Permit Reviews

Permit Number: **SFD1902-0004**

Description: **44x49 sfd mono slab**

Site Address: **55 DAY TRADING CT**

PROPOSED PLOT PLAN - LOT - 90

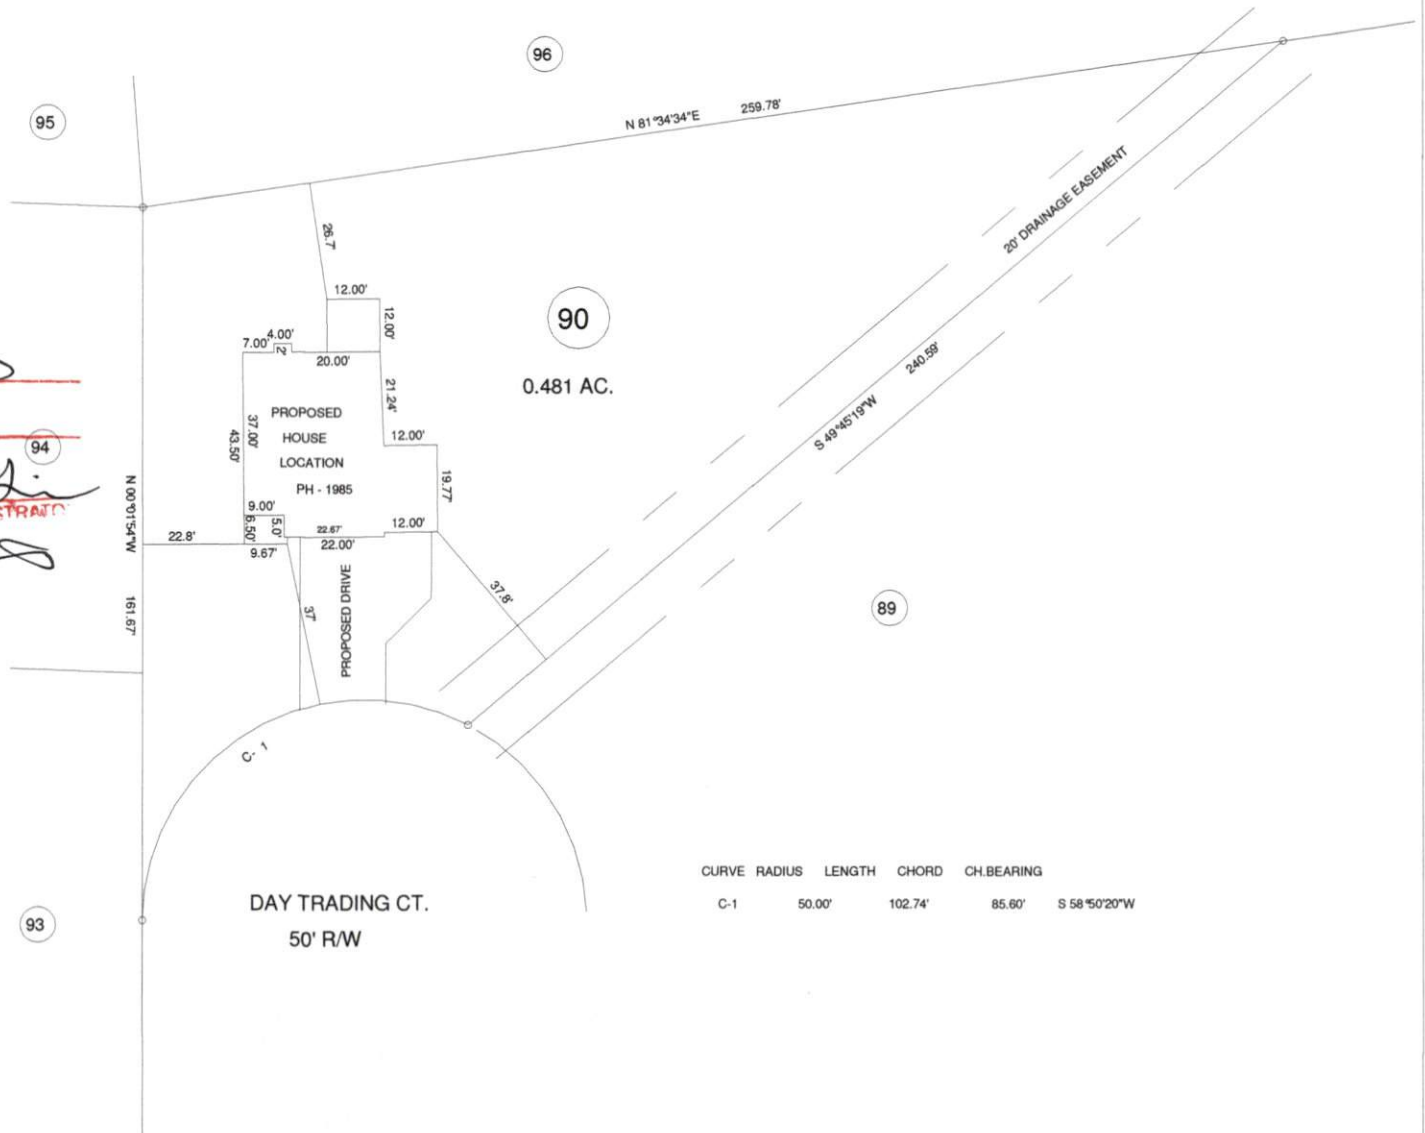
SENT DATE	RETURNED DATE	DUE DATE	TYPE	CONTACT	STATUS	REMARKS
Review Group: AUTO						
2/6/2019	3/4/2019	2/20/2019	ENVIRONMENTAL	Oliver Tolksdorf	APPROVED	
Notes:						
House needs to be moved to 12 from the side property line. Revise site plan.						
2/6/2019			BUILDING	Building Bucket		
Notes:						
2/6/2019			SFD INTAKE	CP Bucket		
Notes:
